**Date: 10/31/2024**

**Re: Porch Column Issue**  
Location: Lot 9 Honeycutt Farm (177 Shelby Meadows Holly Spring, NC)  
JDS Project No.: RDU2410901  
Date of Inspection: 10/31/2024

**TYPICAL PORCH
POST CONNECTION DETAIL**

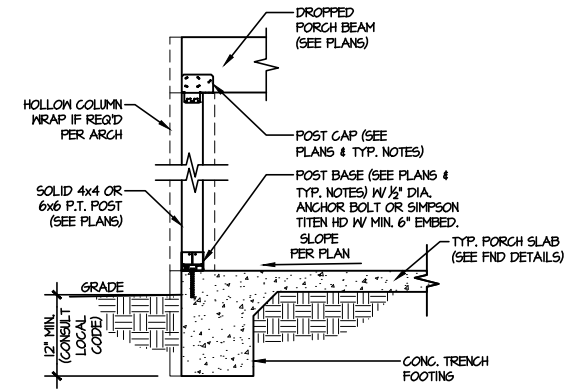
The client requested an evaluation of 6x6 porch columns at the rear porch, the existing post cap hold-downs were installed incorrectly. At the post locations an angle has been installed on one face of the posts to the upper framing, CS-16 straps approximately 32" long have been installed from the posts to the upper rim. The strap at the rear corner post is approximately 16" long.

Based on our observations and review, the repairs to the other posts are adequate as installed, no further repairs are required.
